# **A46 Newark Bypass**

**Scheme Number: TR010065**

## **Statement of Common Ground with Newark and Sherwood District Council 'NSDC'**

**Statement of Common Ground with  
Newark And Sherwood District Council**

- NOTES**
- THIS DRAWING IS TO BE READ IN CONJUNCTION WITH THE DRAFT DEVELOPMENT CONSENT ORDER AND ACCOMPANYING APPLICATION DOCUMENTATION. (TR010065/APP/3.1).

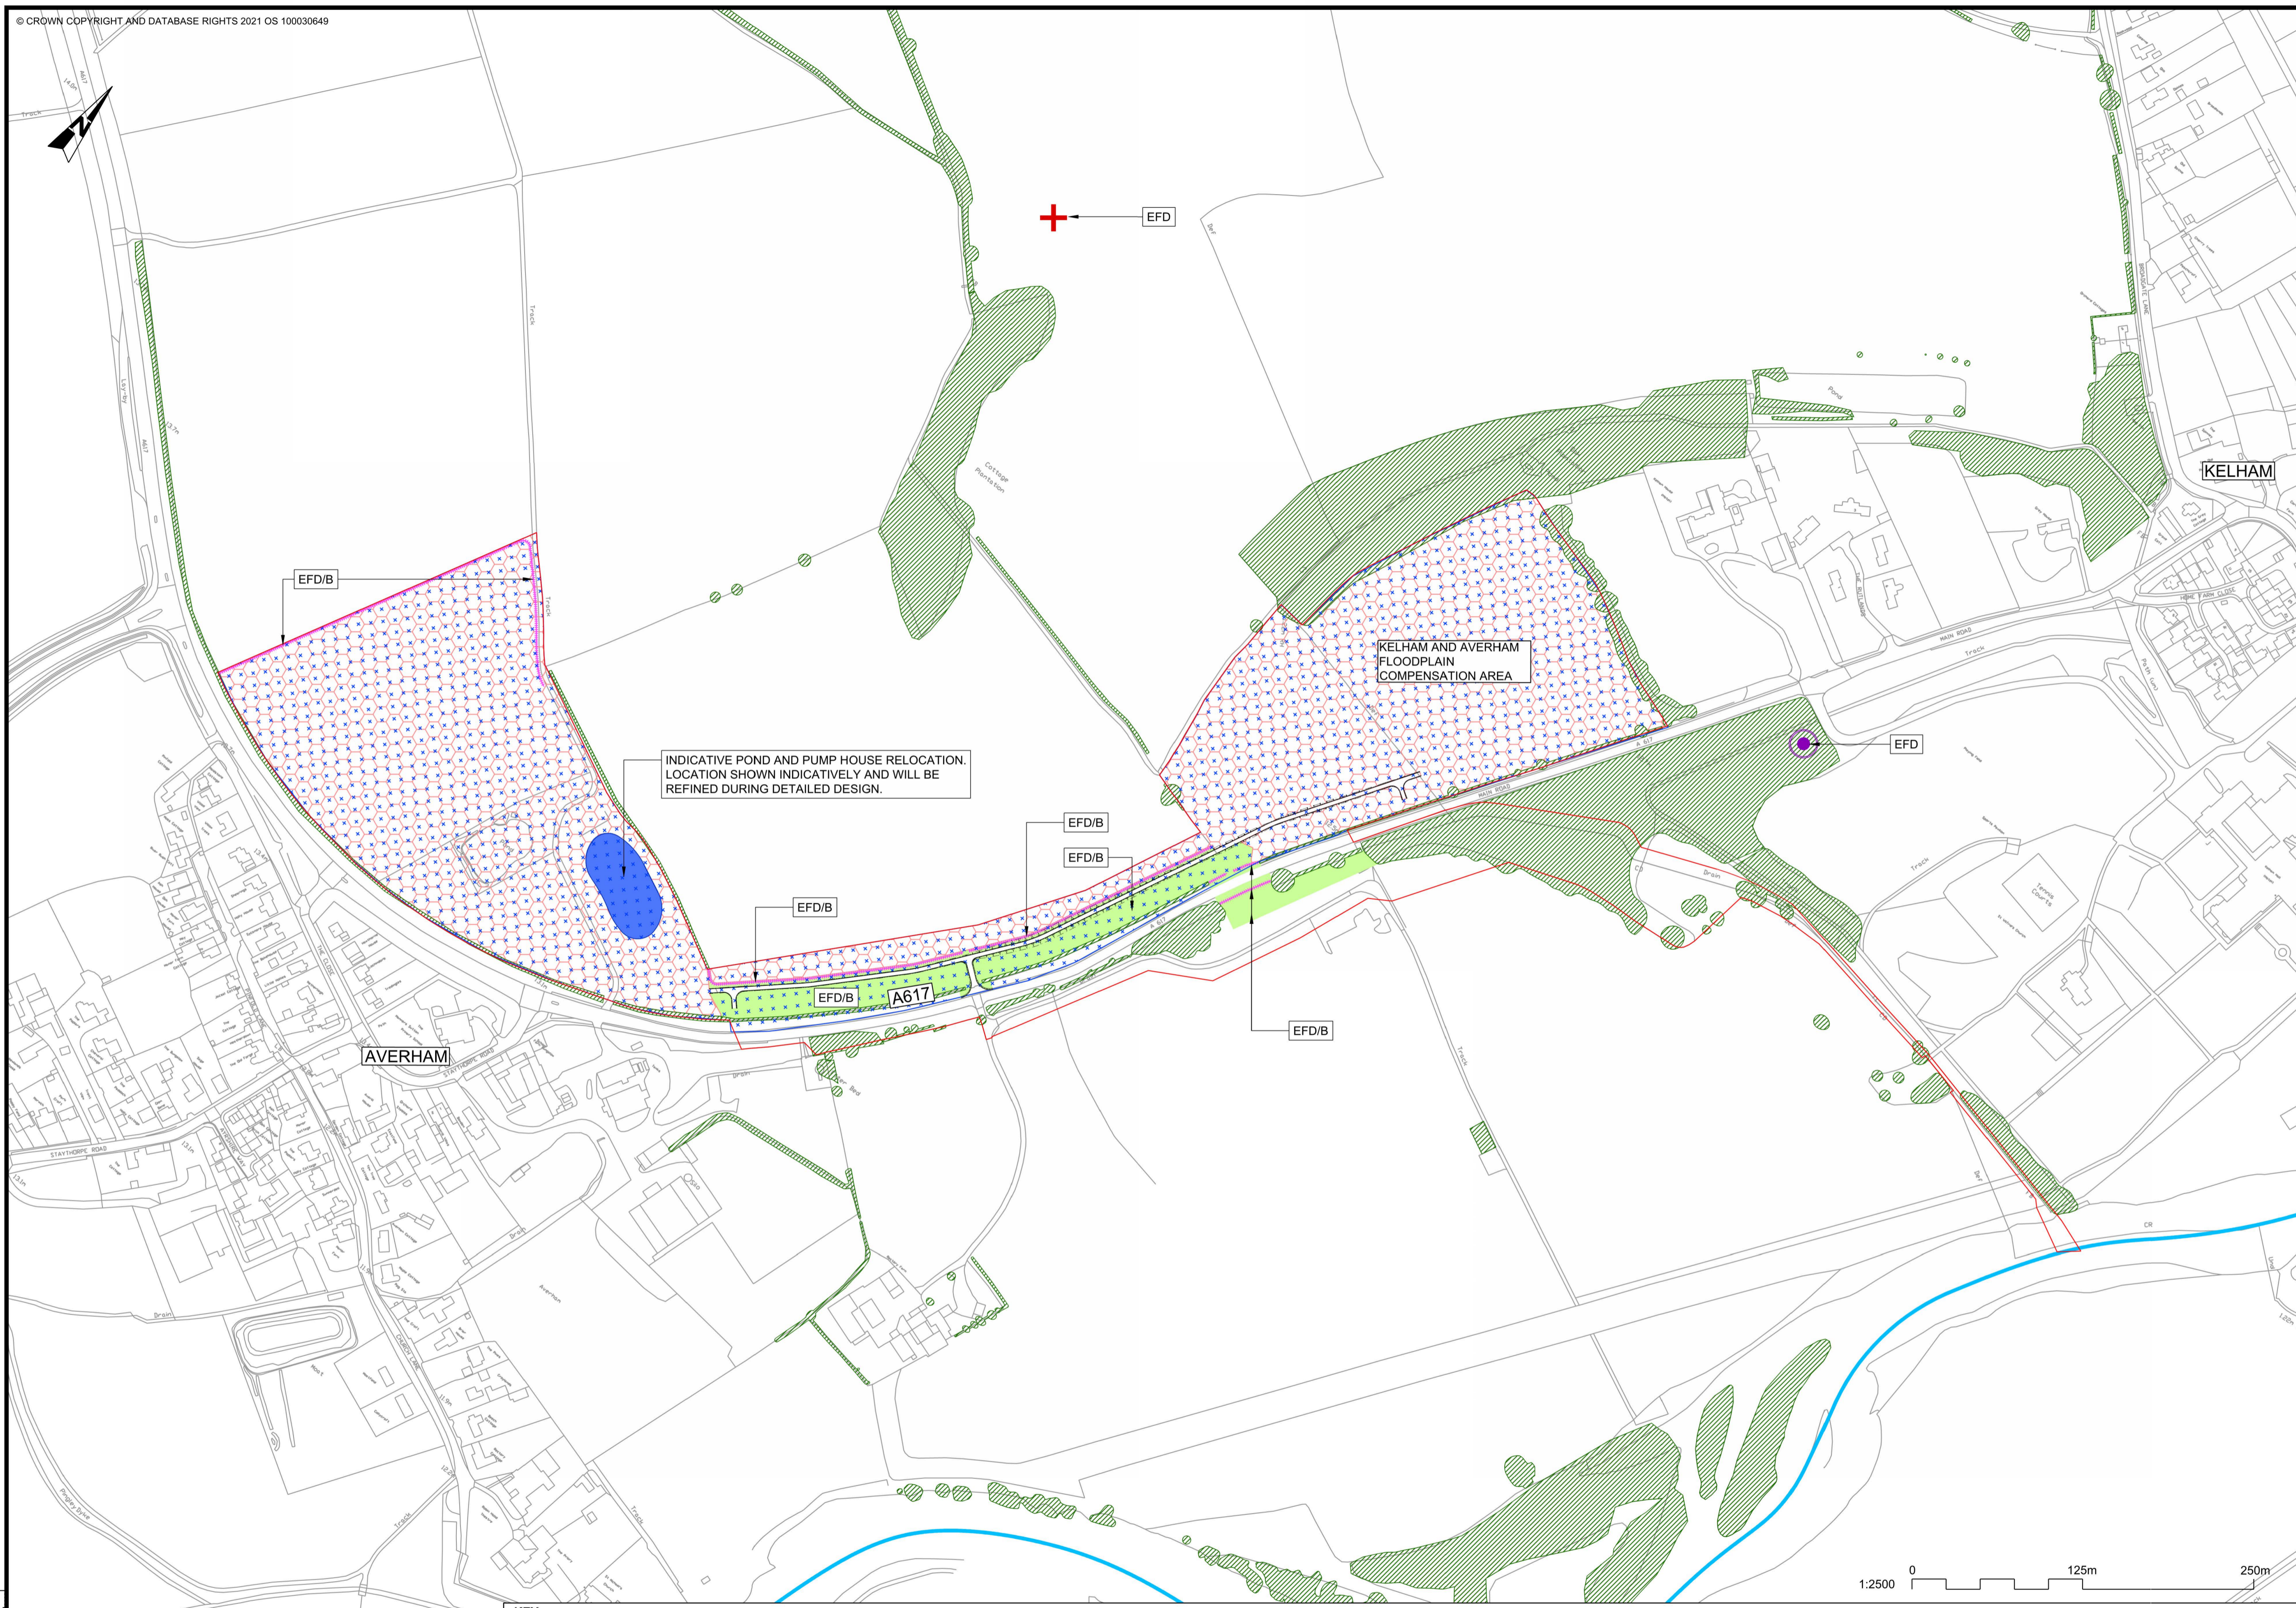
12.	Design (including justification for any flexibility being sought)	<p>Chapter 2 The Scheme of the Environmental Statement [APP-046]</p> <p>6.2 Environmental Statement - Figure 2.3 Environmental Masterplan [AS-026]</p>	<p><b><u>Cattle Market flyover</u></b></p> <p>On the fly-through video the structure of the elevated over-pass at the Cattle Market junction appears as a stark and imposing concrete structure. This may be in part due to the animation which depicts it as being very bright in colour and therefore standing out vividly. The Council would want to understand proposals to ensure the visible impact of the final structure is minimised and/or mitigated as far as practicable.</p> <p>03/02/2025 – Although this structure is now understood we still continue to raise concern with the impact the structure would have on the surrounding area.</p>	<p>Consideration has been given to the aesthetic finish of the structure during the design development to help to reduce the visual prominence of the structure and to reflect finishes on existing structures such as that of Smeaton's Arches just to the north of the new junction. Further details of these can be found within Chapter 2 The Scheme of the Environmental Statement [APP-046] and 6.2 Environmental Statement - Figure 2.3 Environmental Masterplan [AS-026].</p> <p>Planting of trees and shrubs has also been considered and incorporated wherever feasible to help break up the visual mass of the structure, with planting softening the built form and aiding screening over time, particularly from properties such as those in Sandhills Park affording near distance views.</p> <p>The assessment of landscape and visual effects and associated design and mitigation measures are described in 6.2 Environmental Statement - Figure 2.3 Environmental Masterplan [AS-026] and presented in 6.2 Environmental Statement - Figure 2.3 Environmental Masterplan [APP-026].</p> <p>Part of the Detailed Design process will be to define the finish of the retaining walls forming the Cattle Market Flyover. This will be a masonry type façade and not a bare concrete finish.</p>	Not Agreed	20/02/2025
